TfL Post Stage 1 Comments:

Broadwater Lake

Stage 1 Comment: (11 th Dec 2023)	Revised scheme comment: (11 th March 2026)
Access	
Access to the site is via a private access road off Moorhall Road. There are currently no footways or street lighting present on the access road. Improvements to this site access road and junction, which includes the provision of a dedicated pedestrian footway, new street lighting and introduction of a 20mph speed limit are proposed. These improvements have been subject to a Stage 1 Road Safety Audit, the findings of which should be considered with the relevant highway authority.	As the highway authority the RSA should be agreed by Hillingdon. Access improvements have been highlighted including new street lighting. Confirmation of where this is to be located and how this is to be secured is required.
It should be ensured that the proposed access is designed in line with the Mayor's Healthy Streets approach, with priority given to modes of sustainable and active travel over that of private vehicle. On the General Arrangement Plans there are several stretches of access road where the footpath changes sides without any crossing or demarcation. This should b

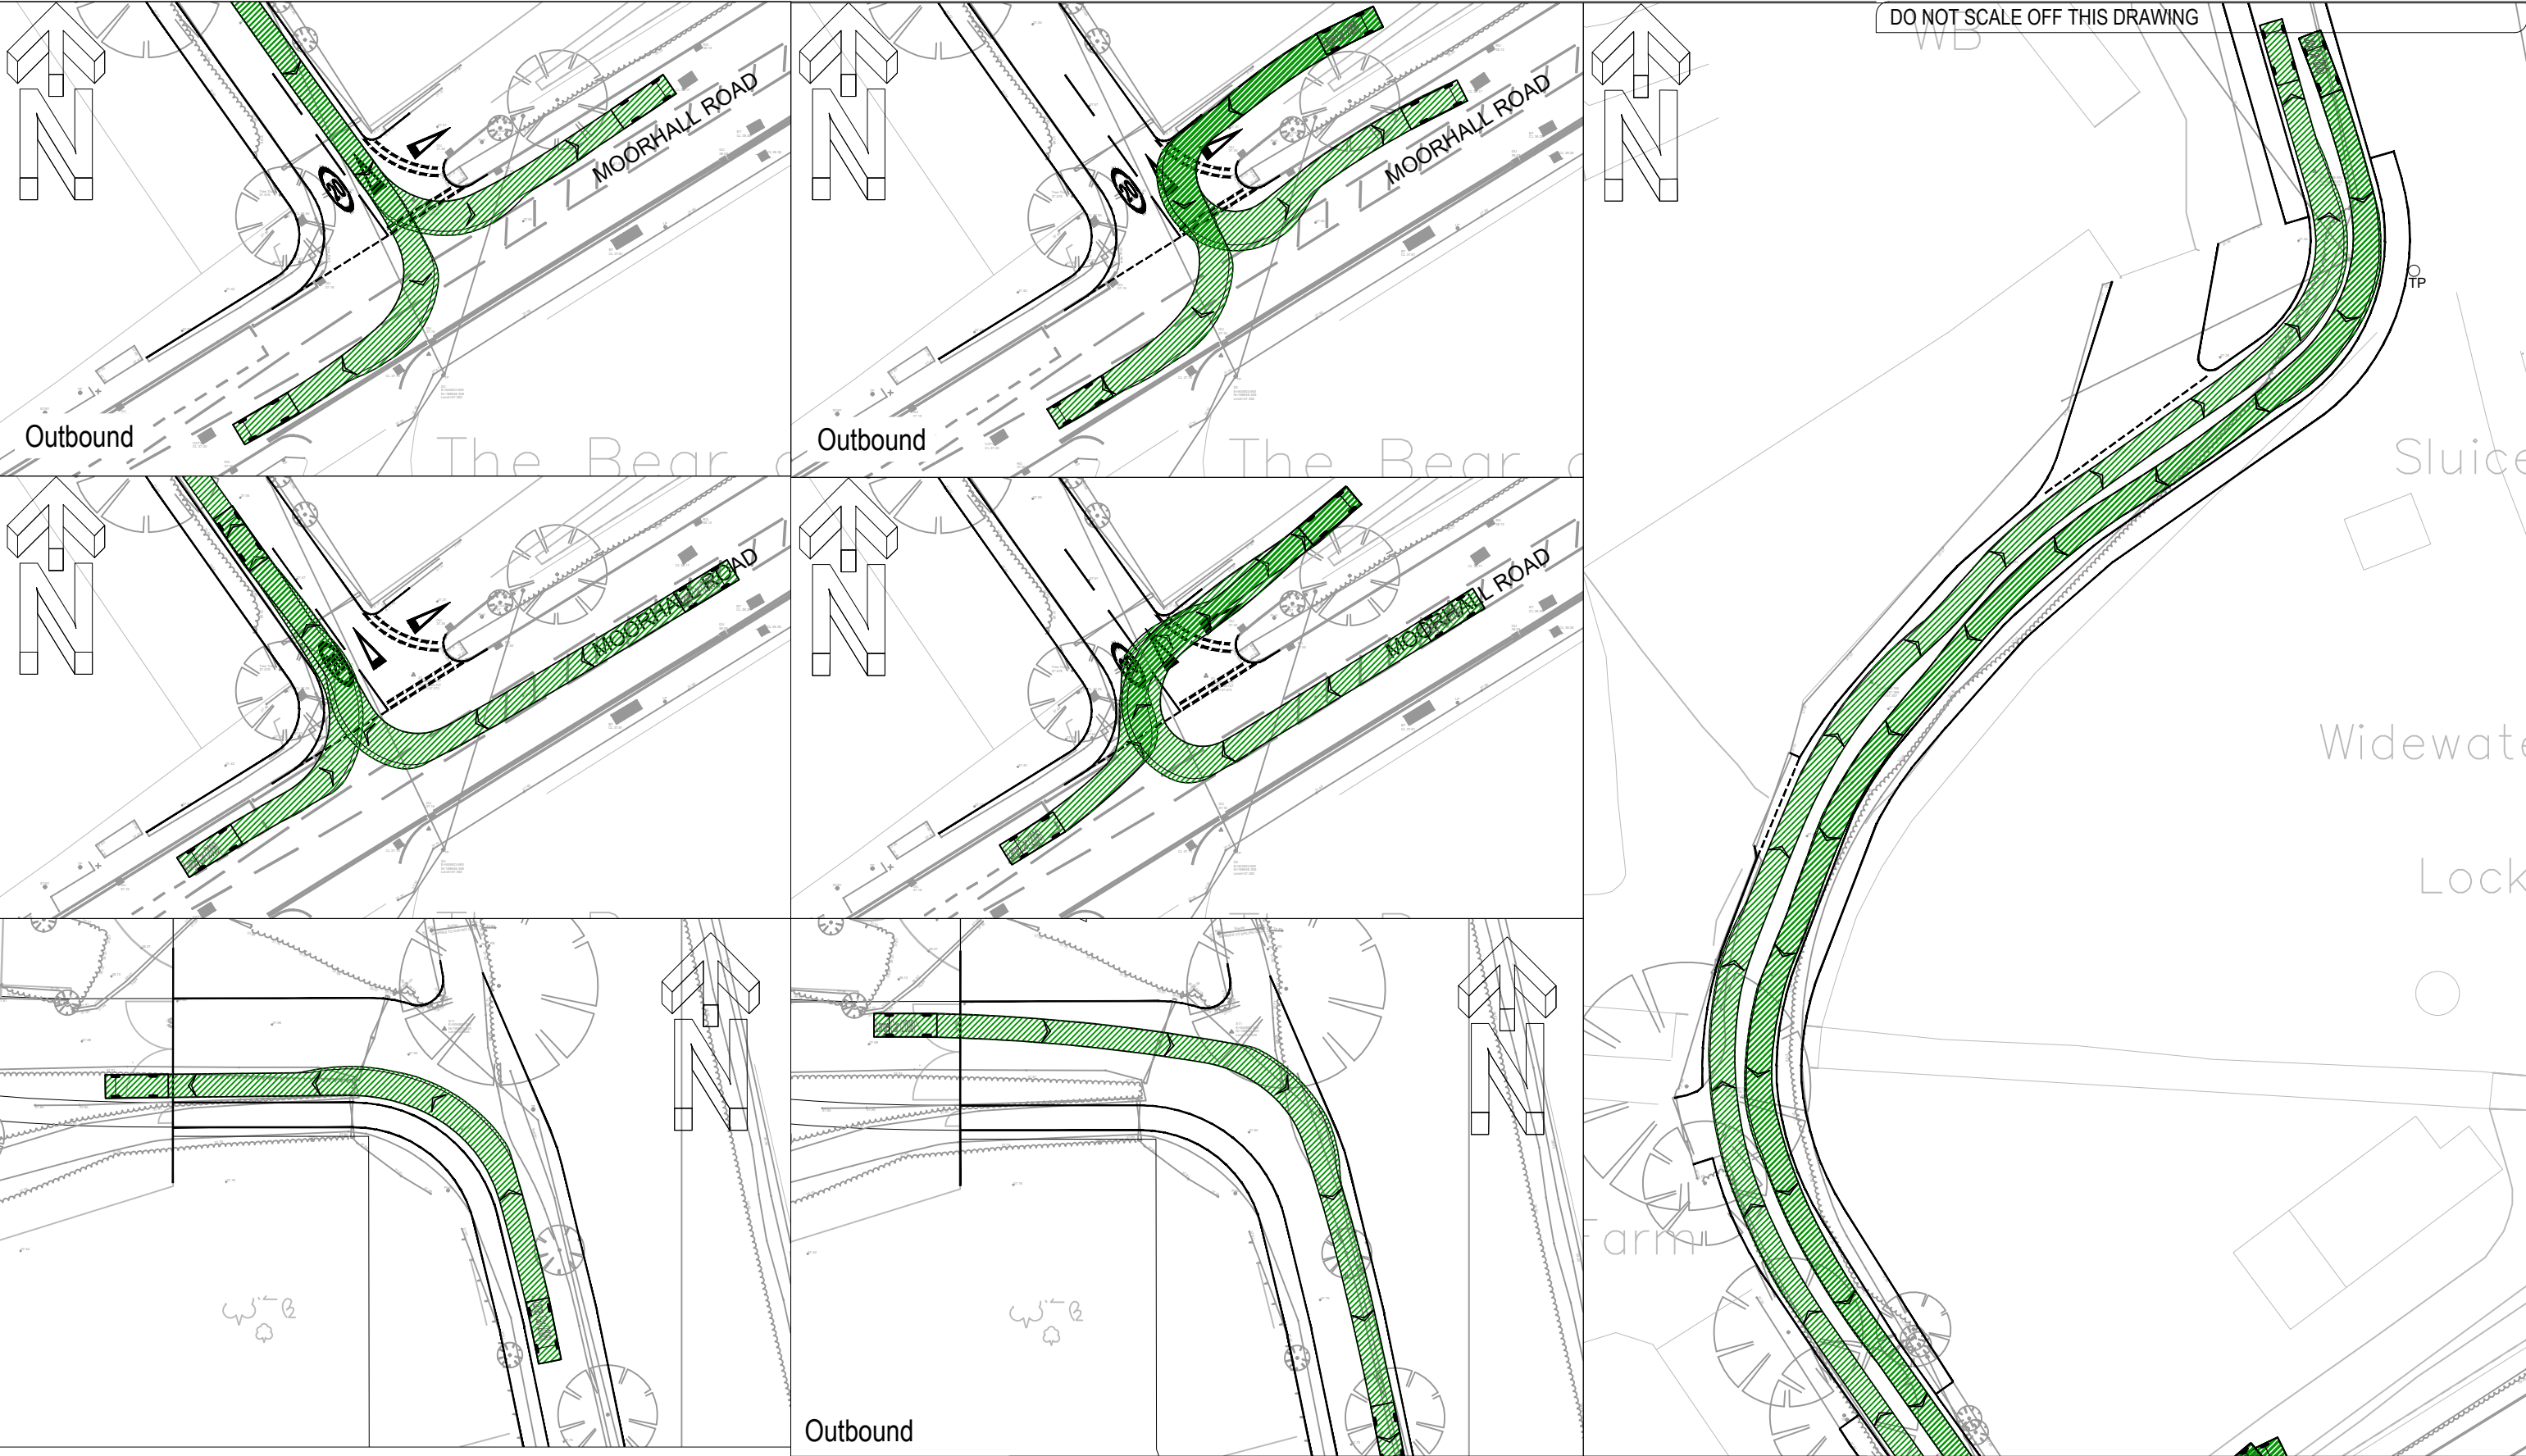
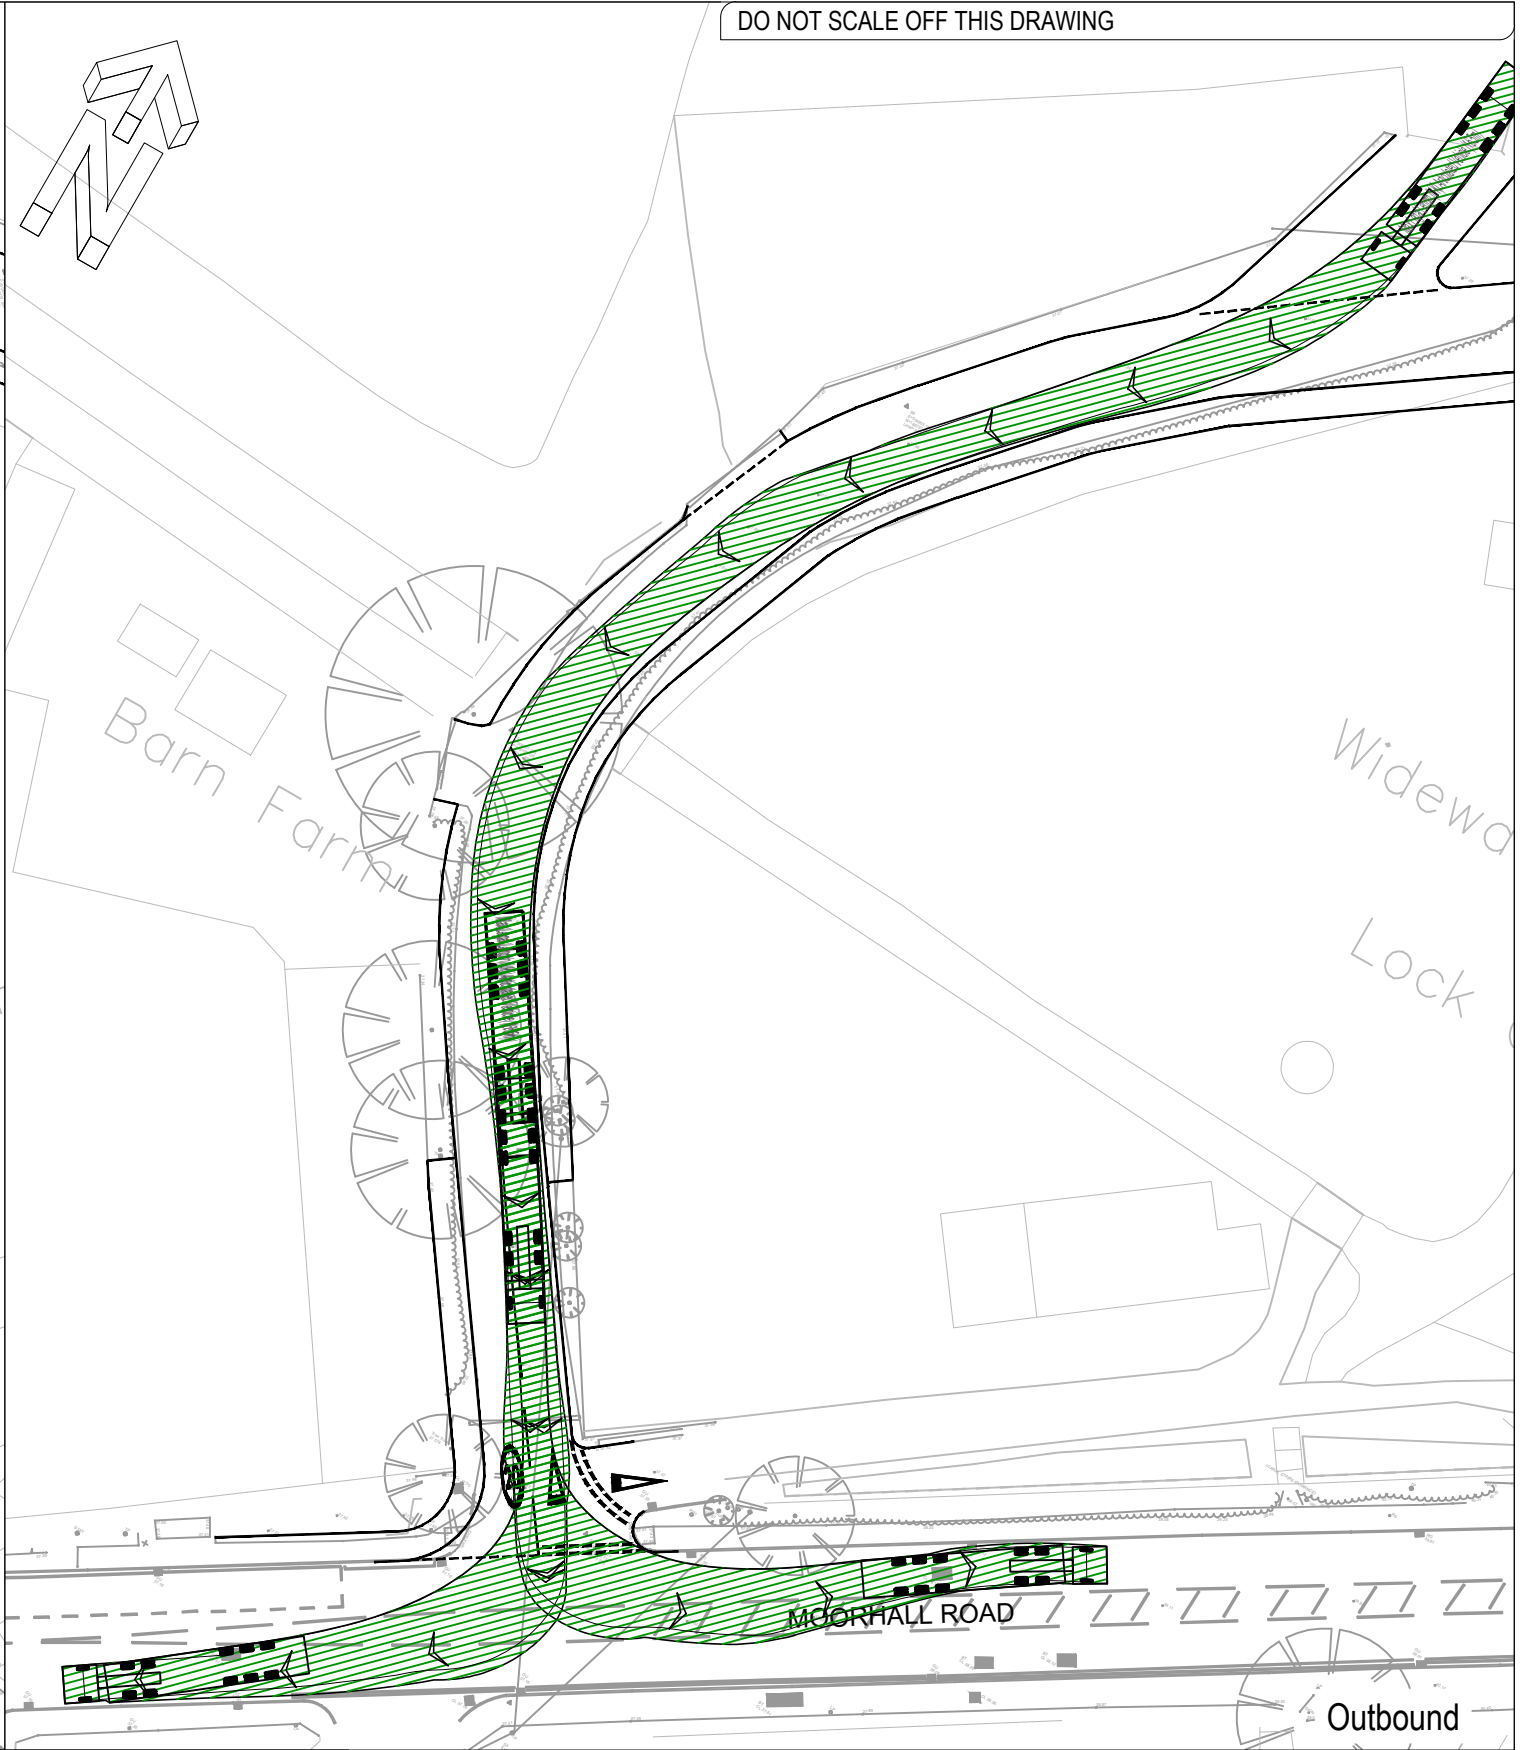
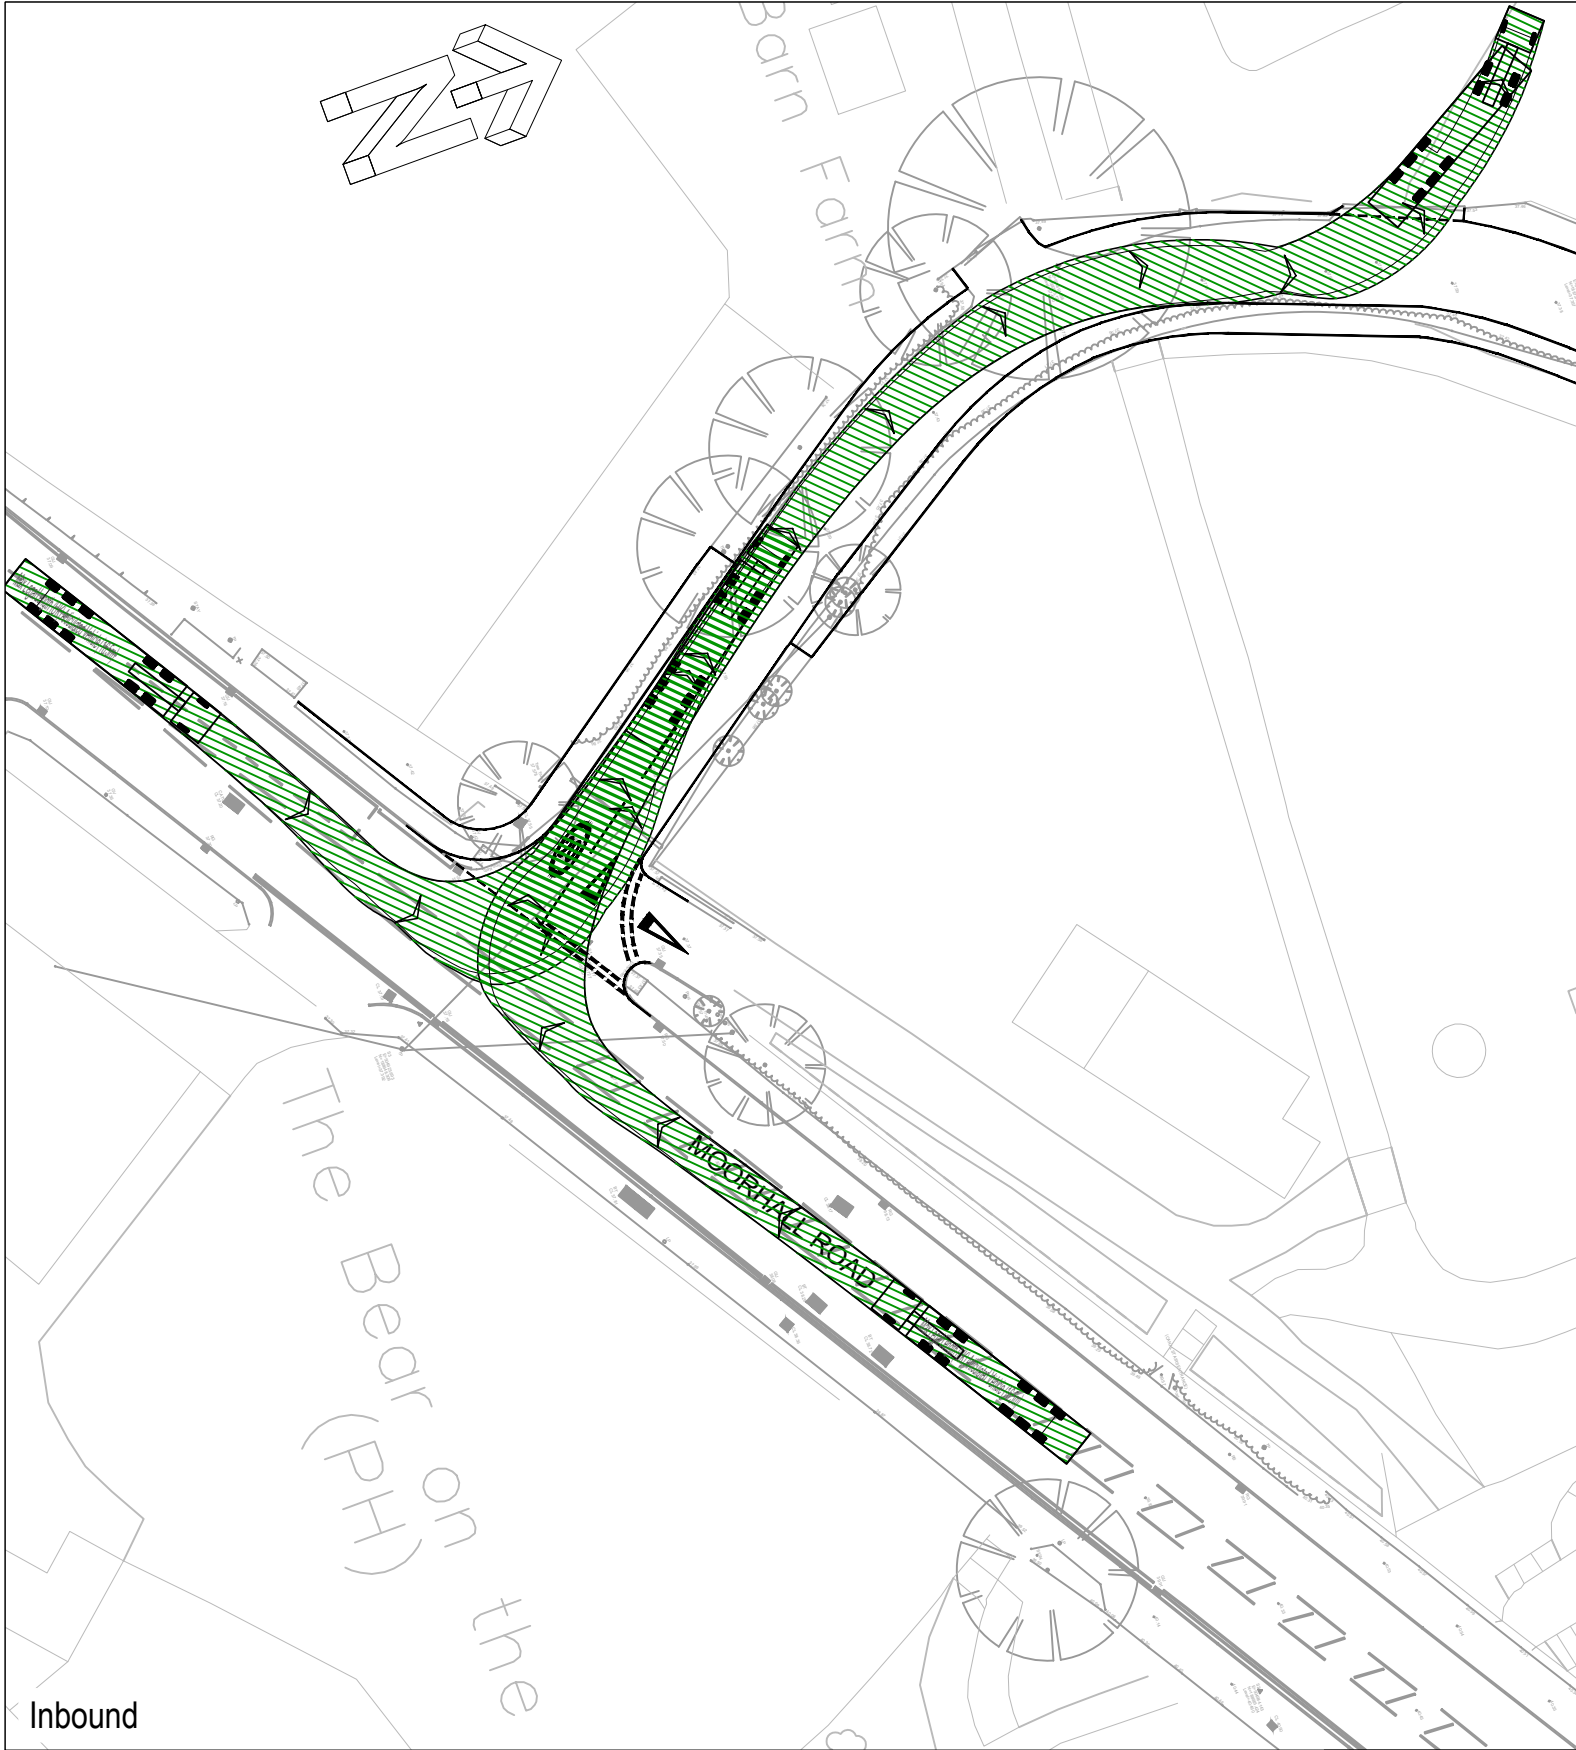
pedestrians. Additionally, the proposed footpath and pedestrian crossings need to be shown more clearly on the swept path analysis. Further information on signage and wayfinding, within the site and on adjoining streets and the canal are required to be delivered.	
Car Parking	
A total of 83 vehicle parking spaces are proposed across the site. As noted in Policy T6.4, parking for leisure uses should be assessed on a 'case-by case basis, ensuring that it is consistent with the Healthy Streets Approach, mode share and active travel targets, and the aim to improve public transport reliability and reduce congestion and traffic levels.' No clarity has been provided on how the figure of 83 was arrived at. Furthermore, when noting the information on number of peak users over a day, there is a concern that 83 parking spaces is a significant overprovision	<i>'A total of 42 vehicular parking spaces are provided'</i> , plus drop off facilities. This represents a reduction of 41 spaces from the previous scheme, which TfL welcomes. However, further information on how the car parking figure has been arrived at is required in order to ensure the proposals meet all relevant London Plan policy and robustly demonstrates case by case parking policy. TfL also query the ability for informal parking on the access roads. Appropriate design and management measures should be implemented to ensure there is no overspill parking.
